## Inspector's Report

### ABP-321255-24

<b>Development</b>	Ballinclare Quarry, Proposed Material Recovery / Recycling Facility and Inert Landfill
<b>Location</b>	In the townlands of Ballinclare and Carrigmore, near Kilbride, Co. Wicklow
<b>Planning Authority</b>	Wicklow County Council
<b>Applicant(s)</b>	Kilsaran Concrete Unlimited Company
<b>Type of Application</b>	Application for approval Permission under 37E of the Planning and Development Act 2000, as amended
<b>Prescribed Bodies</b>	Development Applications Unit. Eastern Midlands Connacht Ulster and Southern Regional Waste Management Planning Offices. Geological Survey of Ireland. Health Services Executive.

NORTH

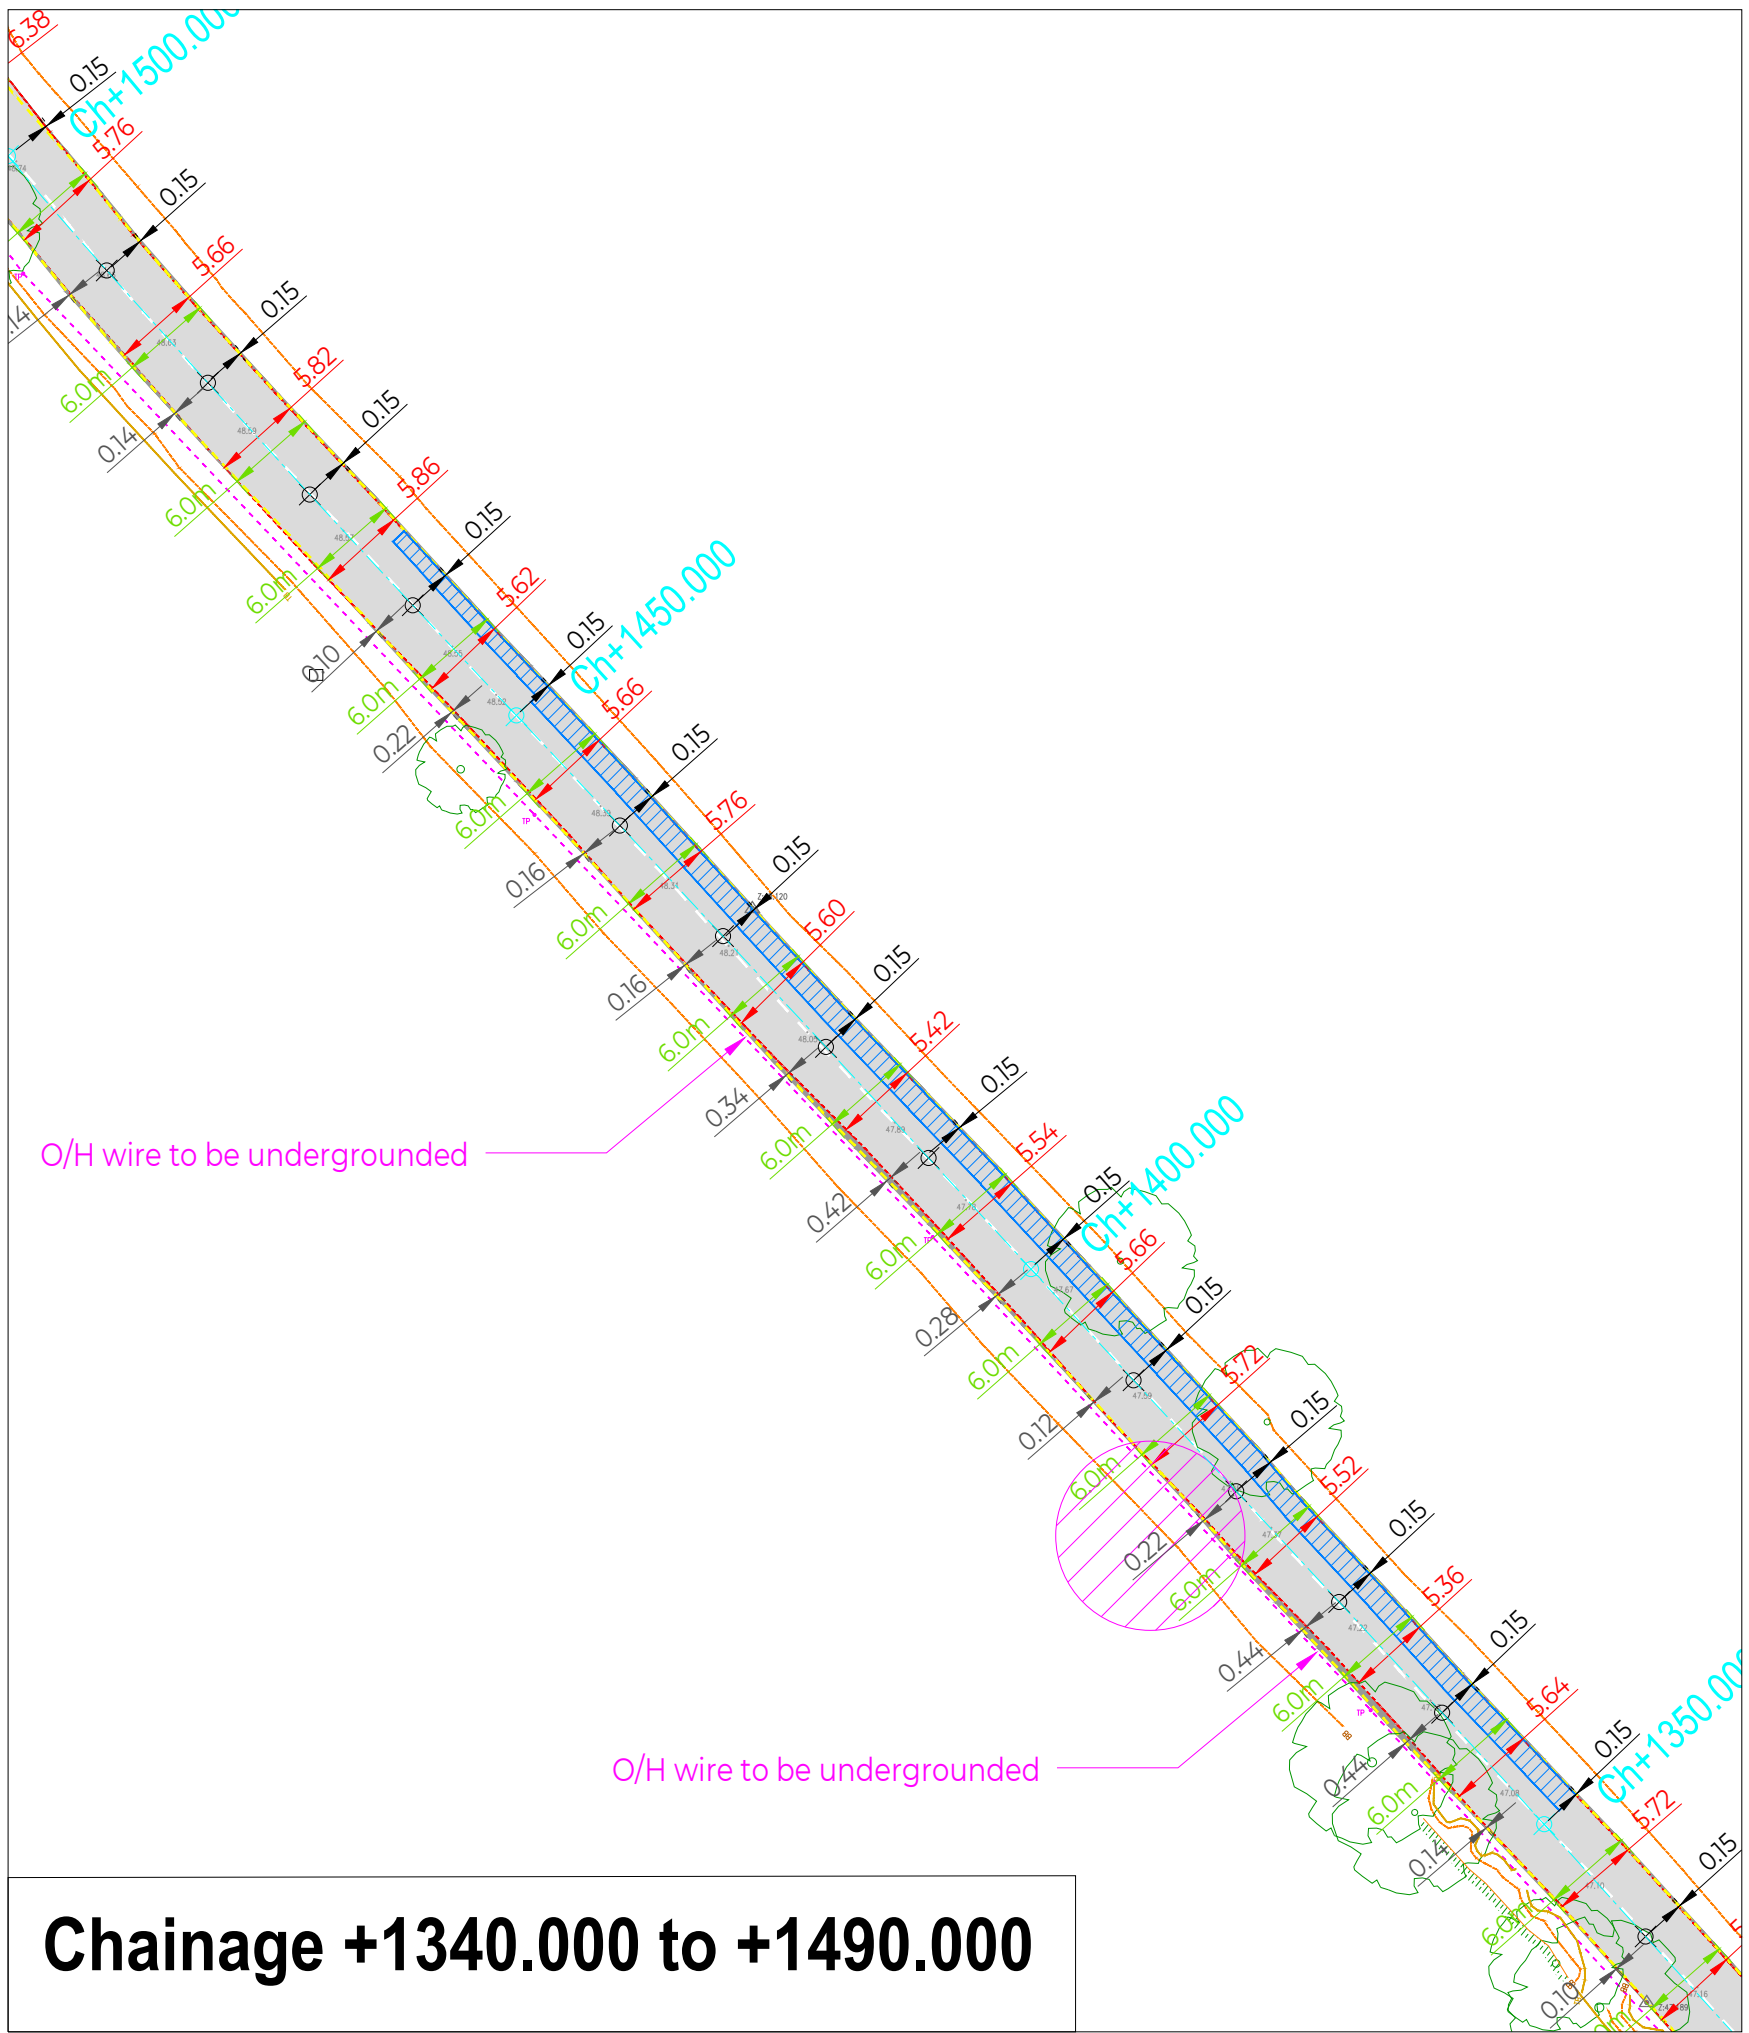
- Recommend a condition that the developer submit appropriate plans and details for the proposed road strengthening works on Local Road L1157 associated with M11 overpass 'Eirspan Structure no: BM-M11-046.00.' The plans and details shall demonstrate compliance with TII Publications and shall also ensure the 5.3m clearance shall be maintained over the extents of the new road layout on the Local Road L1157.

Drawing Number <b>FIGURE 2-2</b>	Rev. <b>2</b>
-------------------------------------	------------------

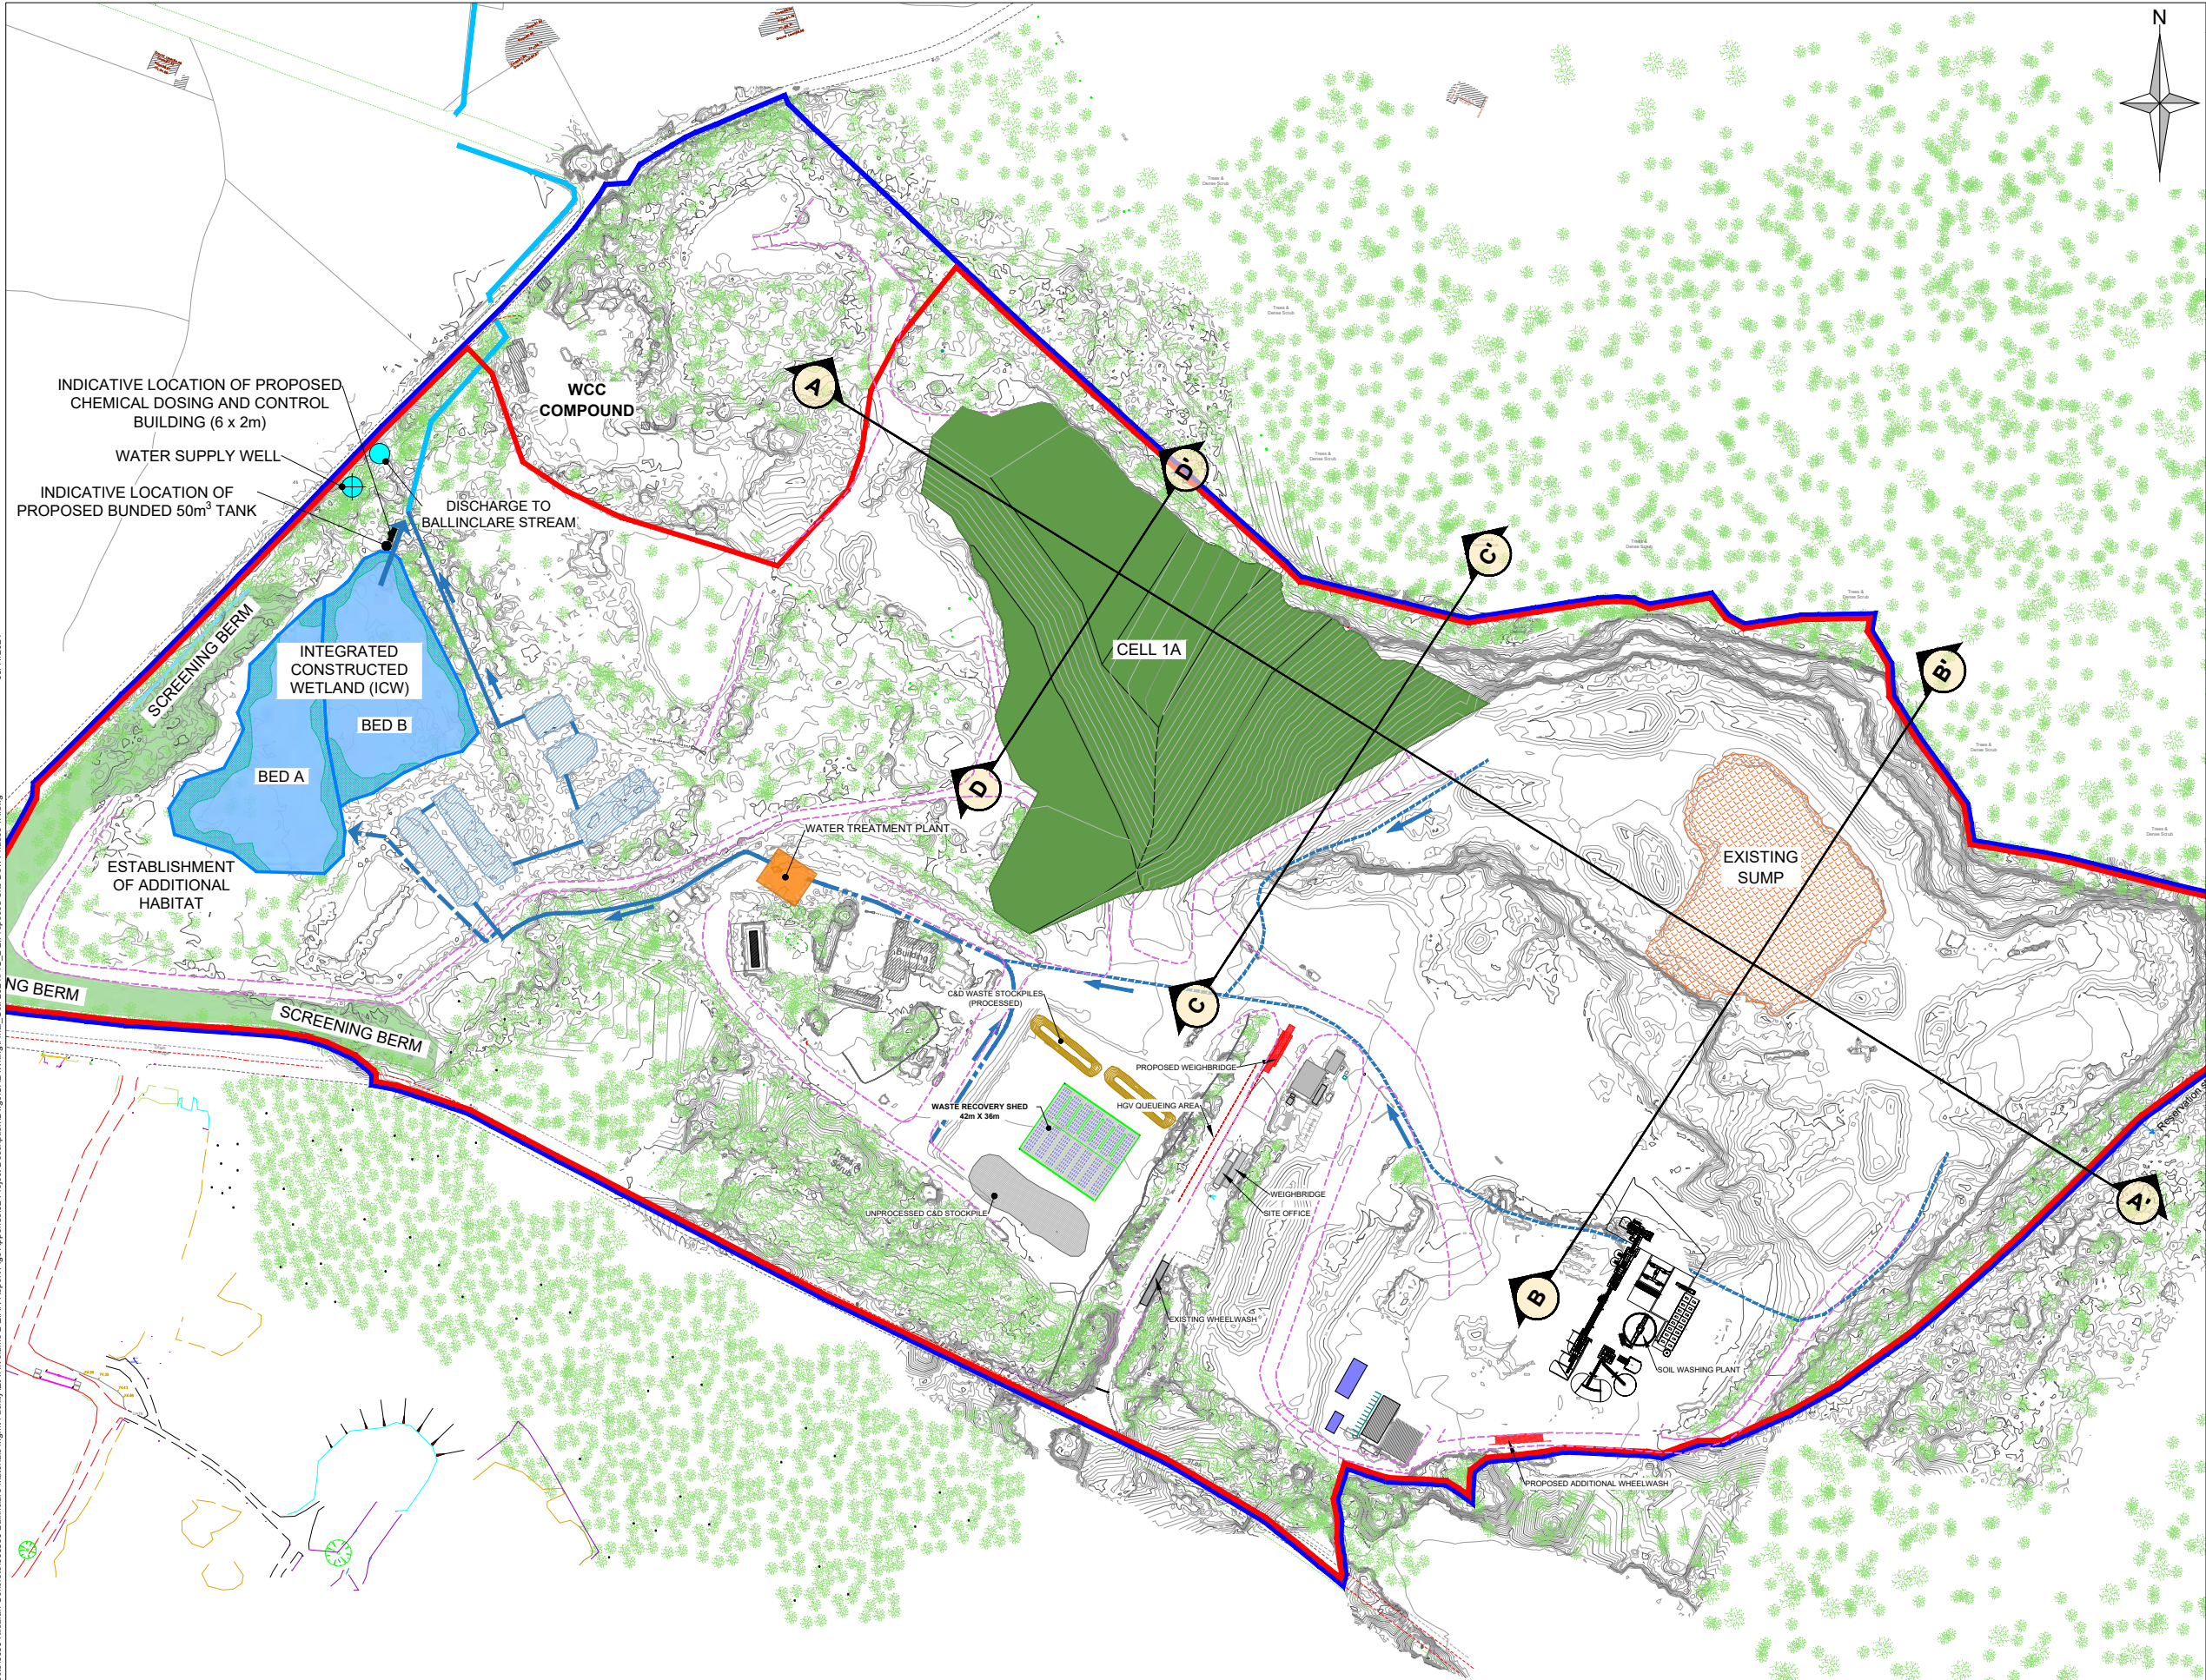
- No objections in principle to the proposed development as it is in line with the National Waste Management Plan 2024 -2030.
- A testing regime would be required to confirm no impact on groundwater from the development.
- Silt trapping measures to be incorporated into the proposed widened section of the haul route given proximity to Potters River. Clarity required on silt and hydrocarbon trap measures around the entrance, wheel-wash and weighbridge.
